ENG-SF21021-R2-Plat.pdf Markup Summary

RETREAT AT TIMBERRIDGE
FILING NO. 2
JOB NO. 1185.20
JANUARY 4, 2021
SHEET 3 OF 7

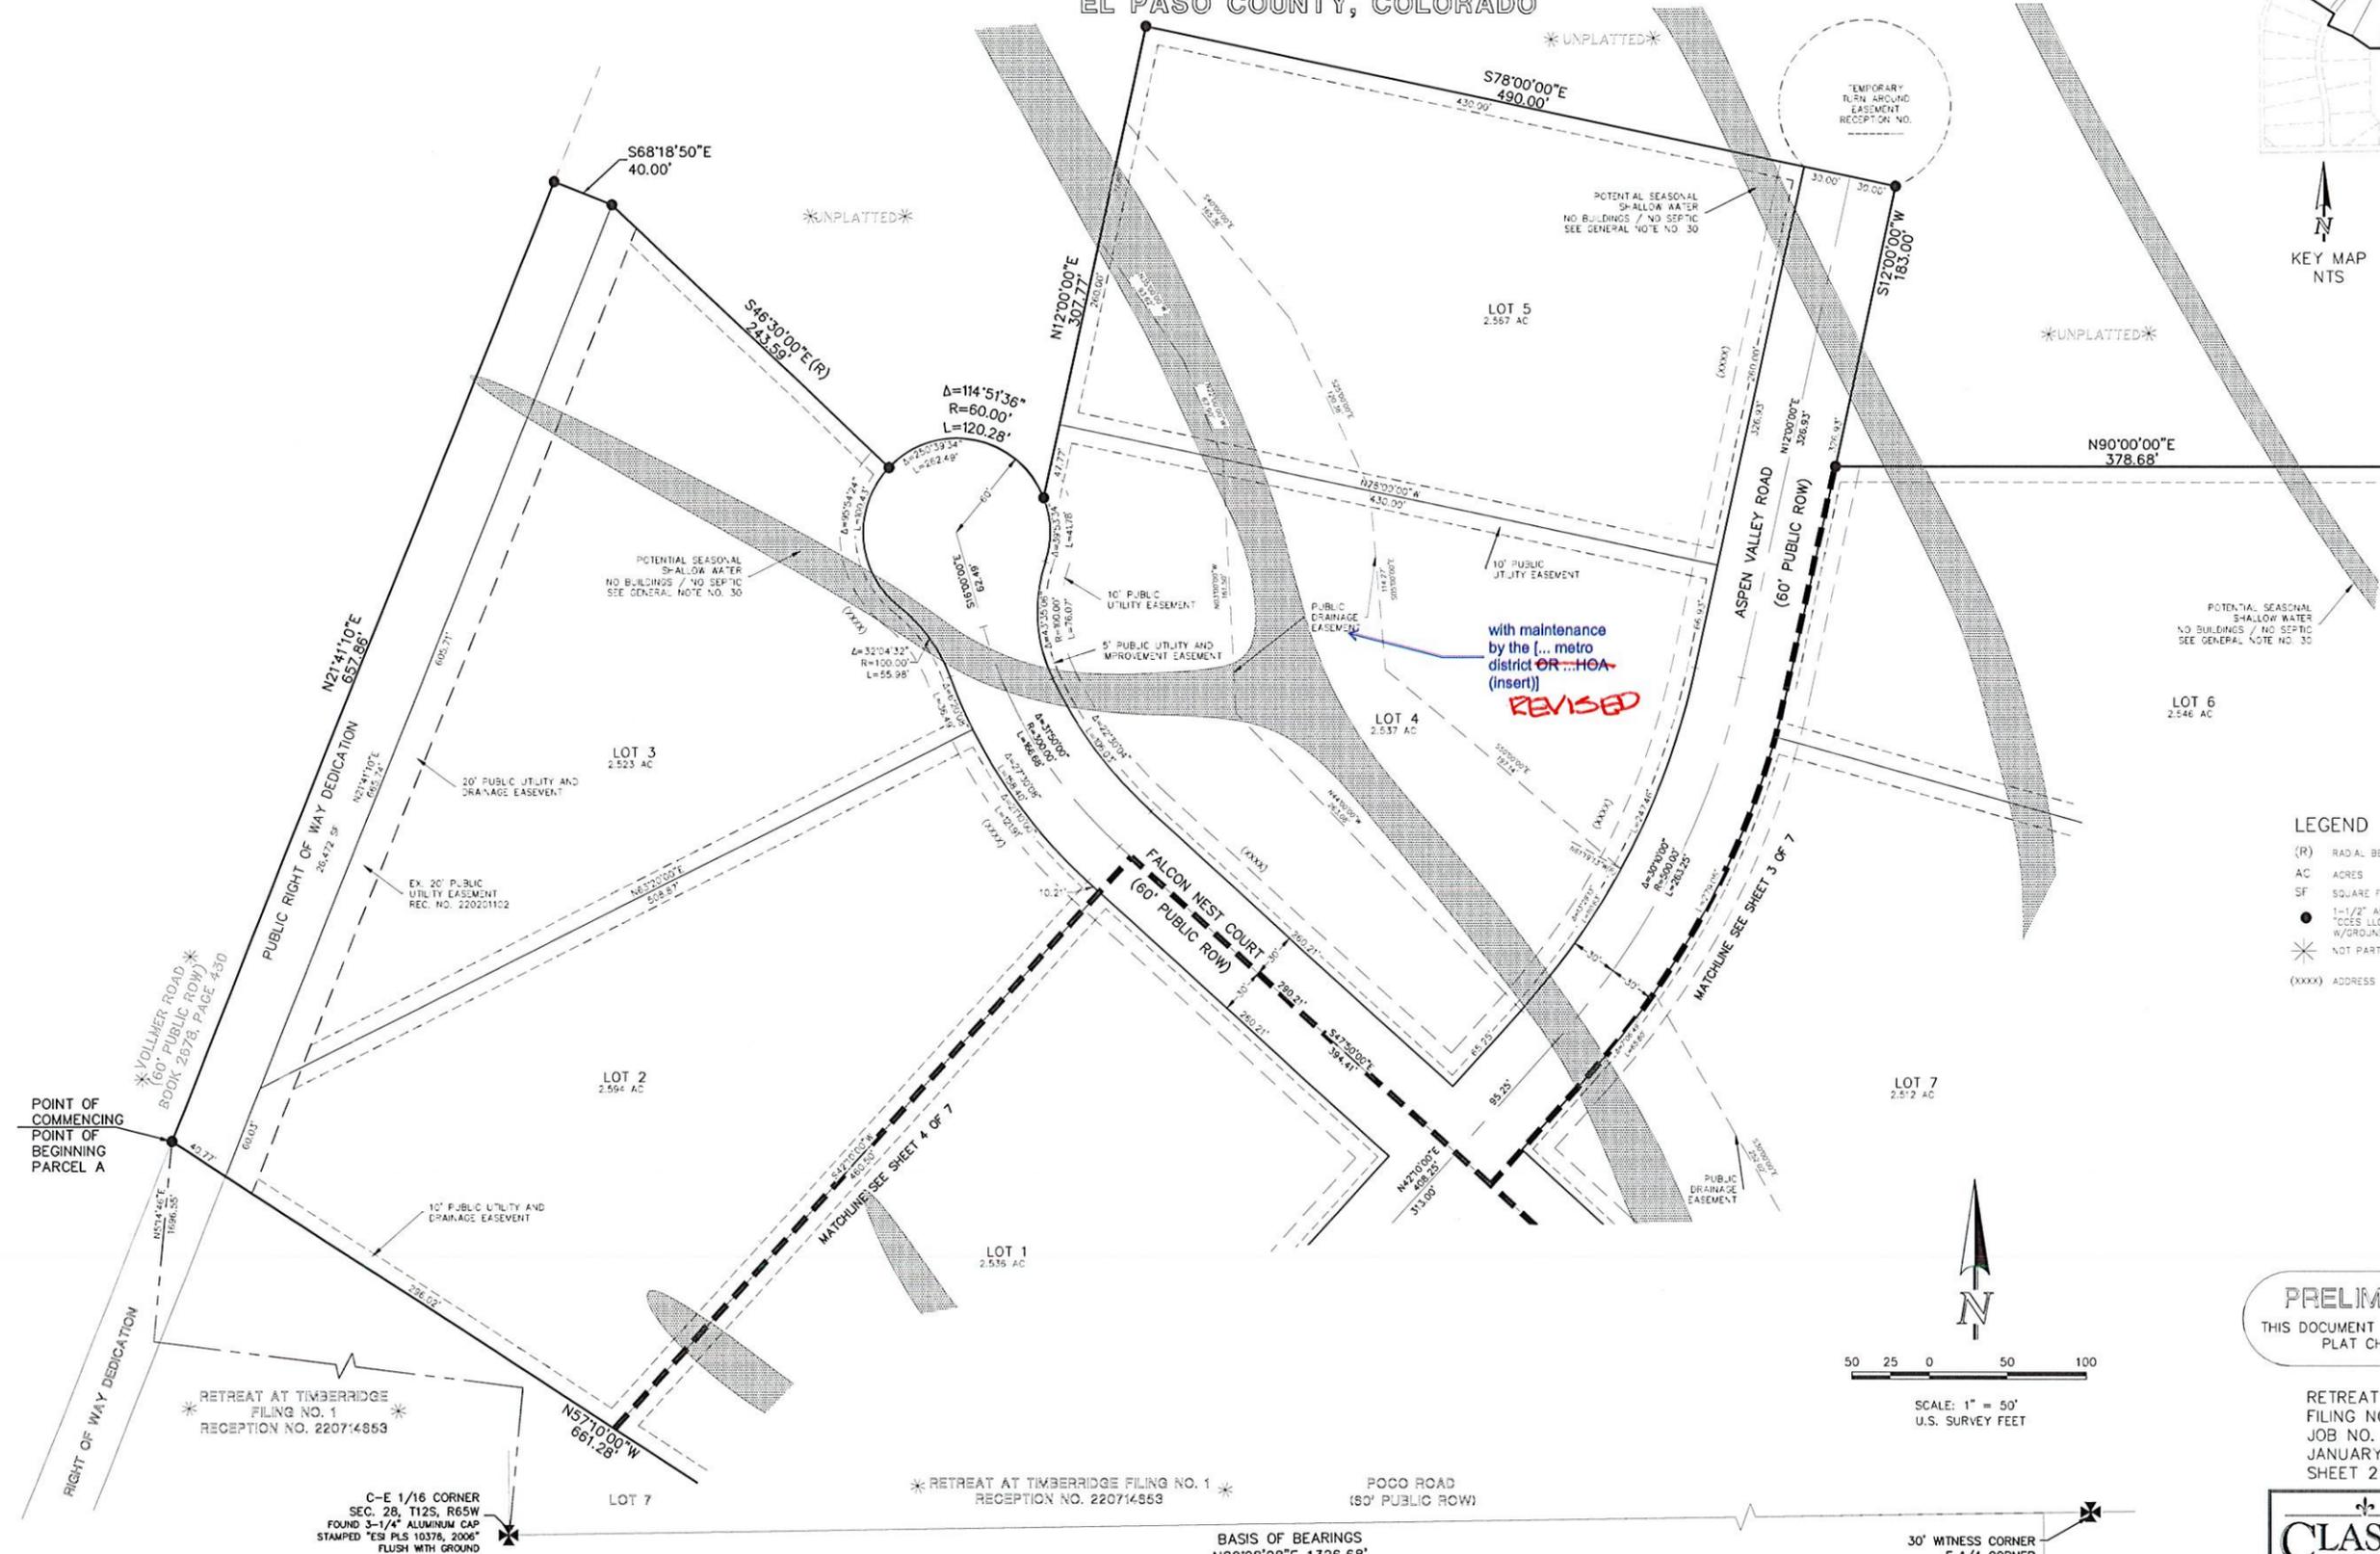
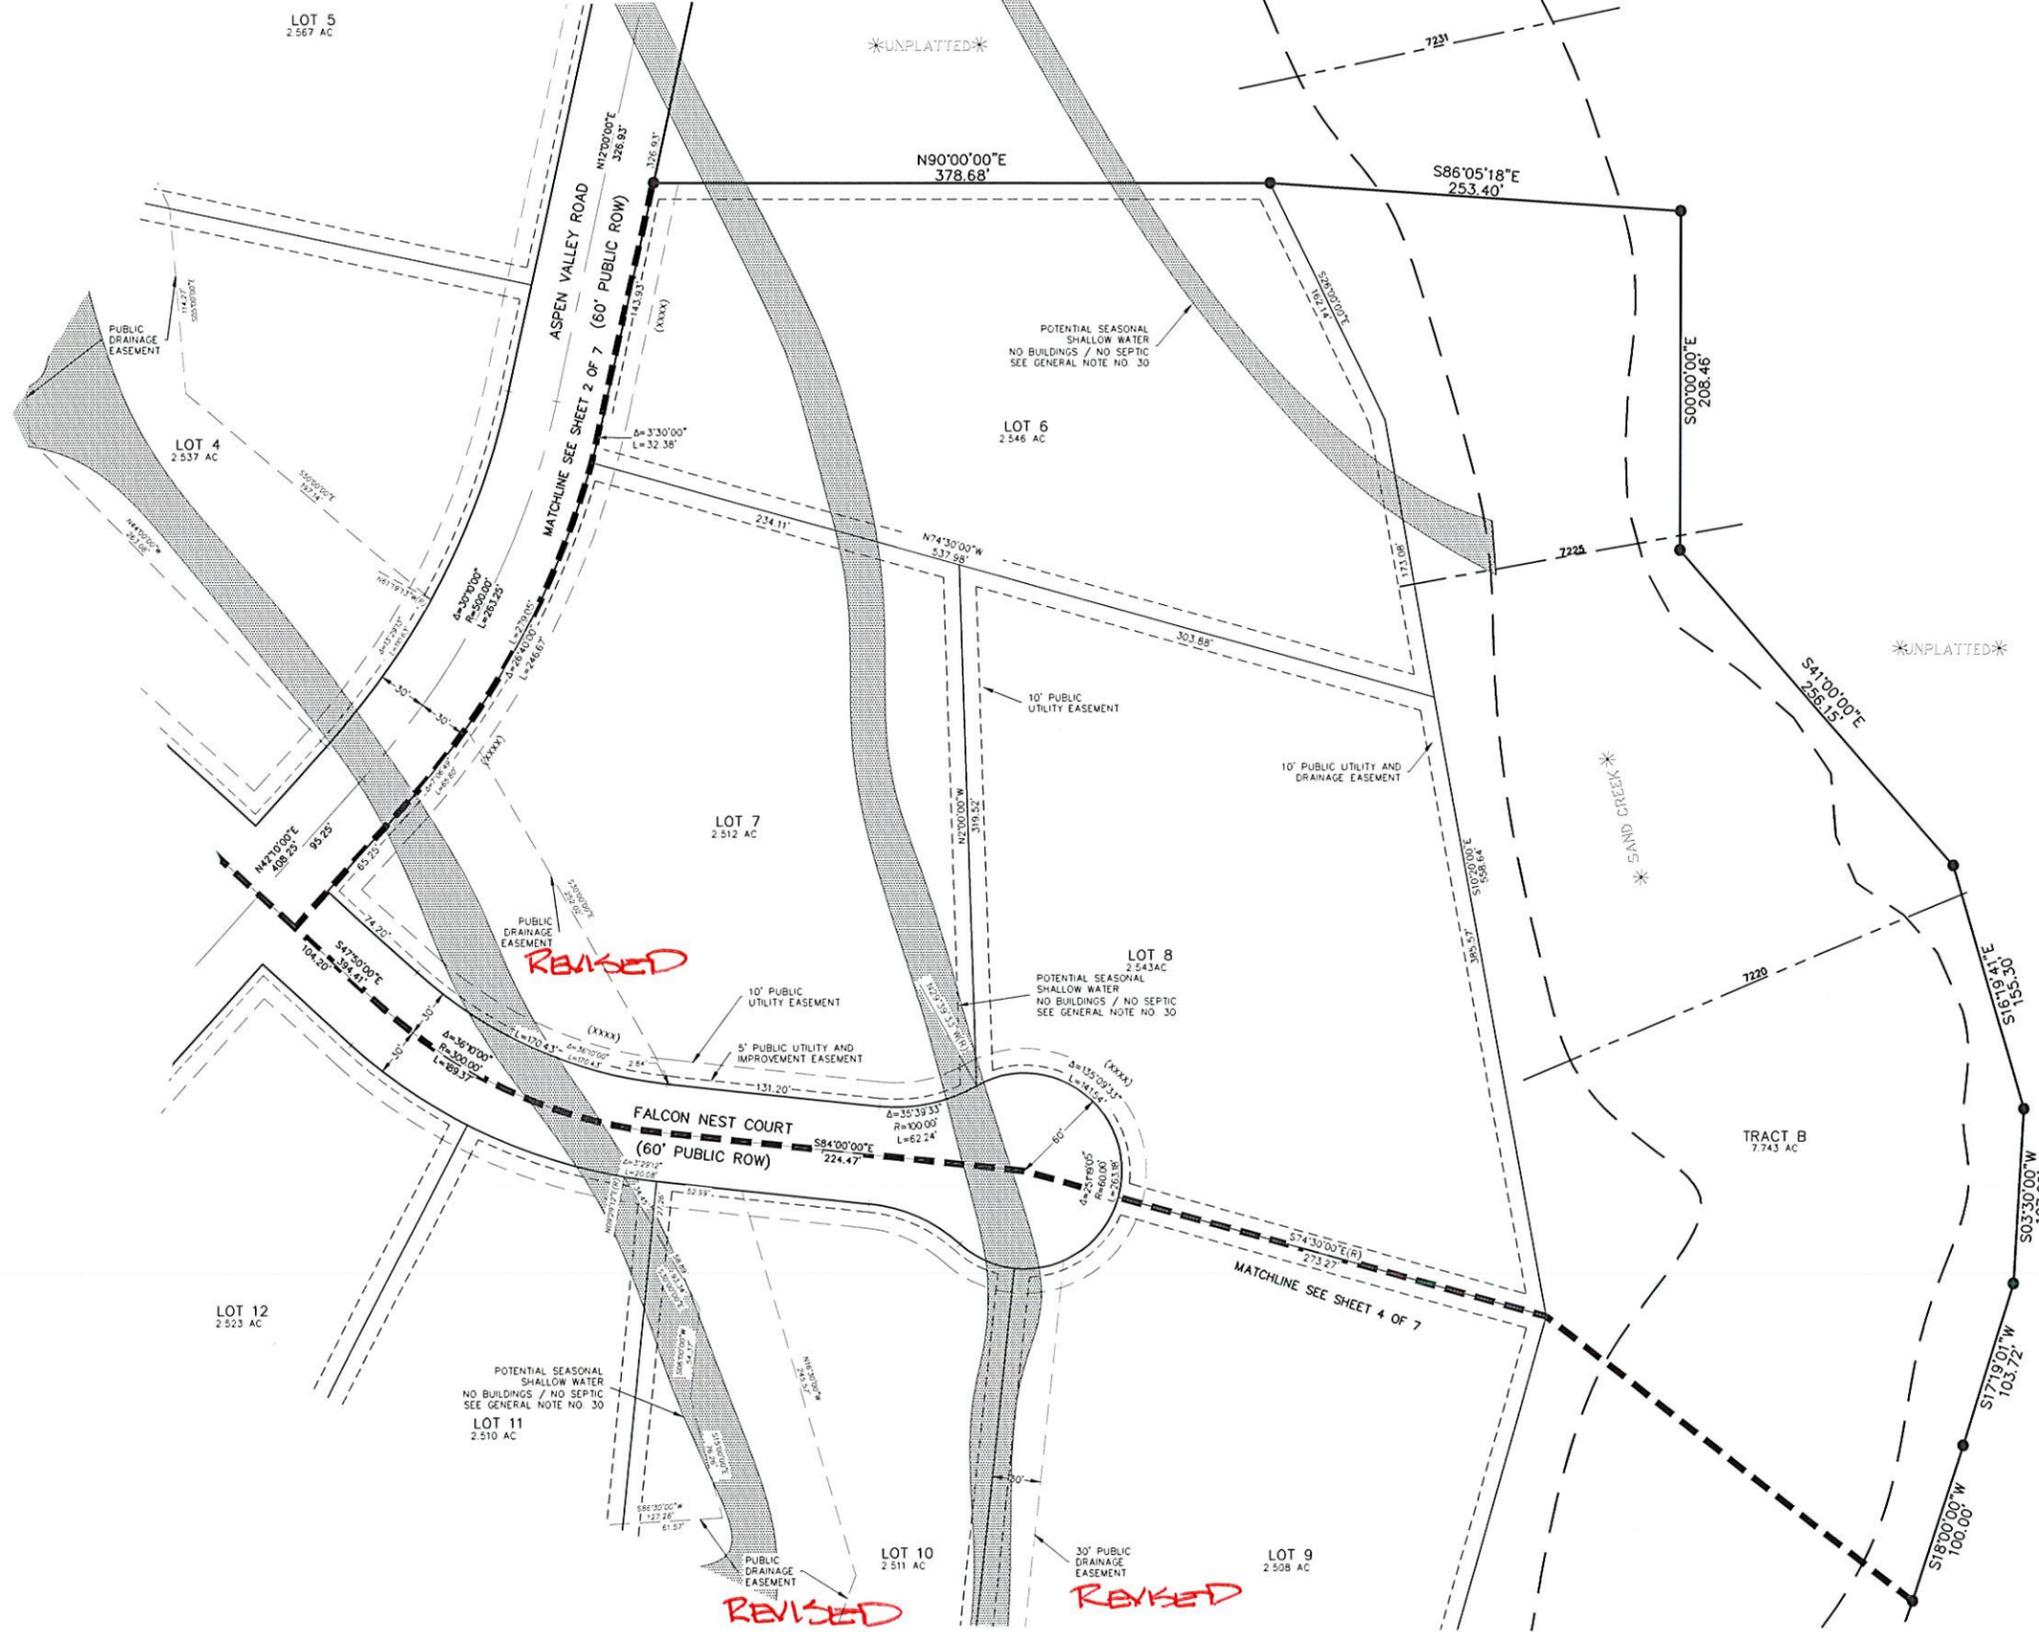
with maintenance by the [... metro district OR ...HOA (insert)]

RETREAT AT TIMBERRIDGE
FILING NO. 2
JOB NO. 1185.20
JANUARY 4, 2021
SHEET 6 OF 7

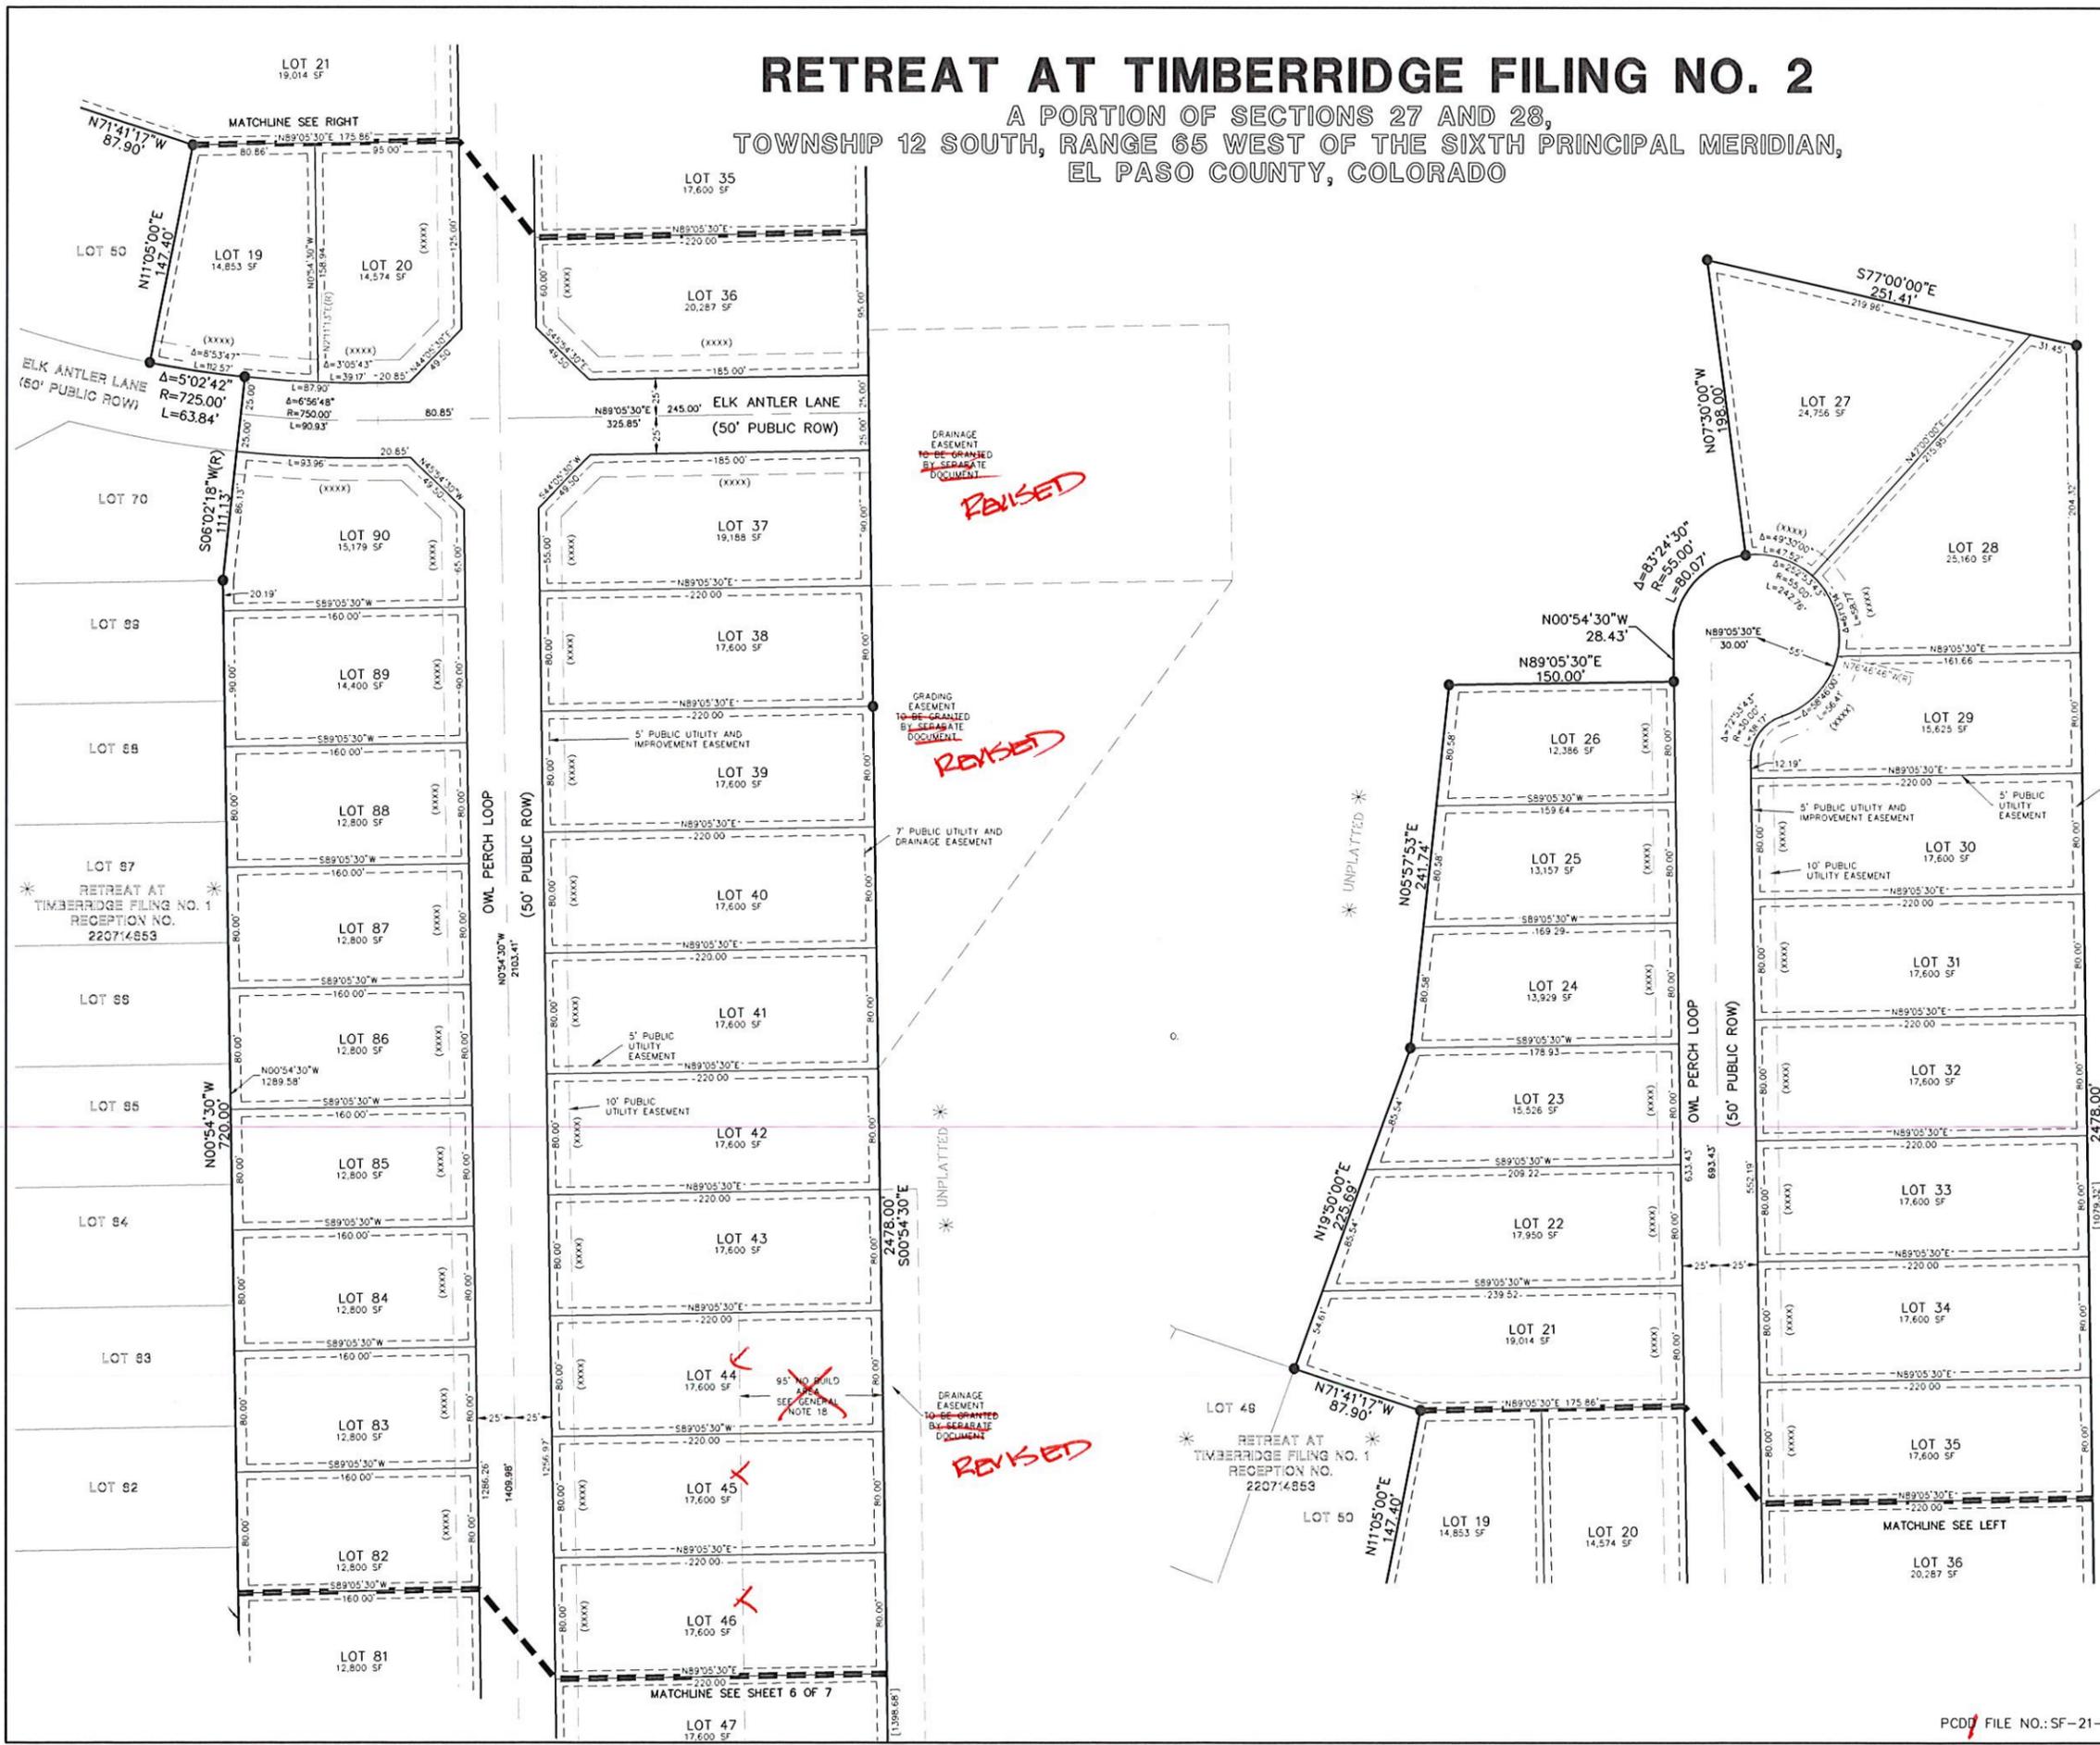
Provide no-build area on Lots 13-16 per WQ plan
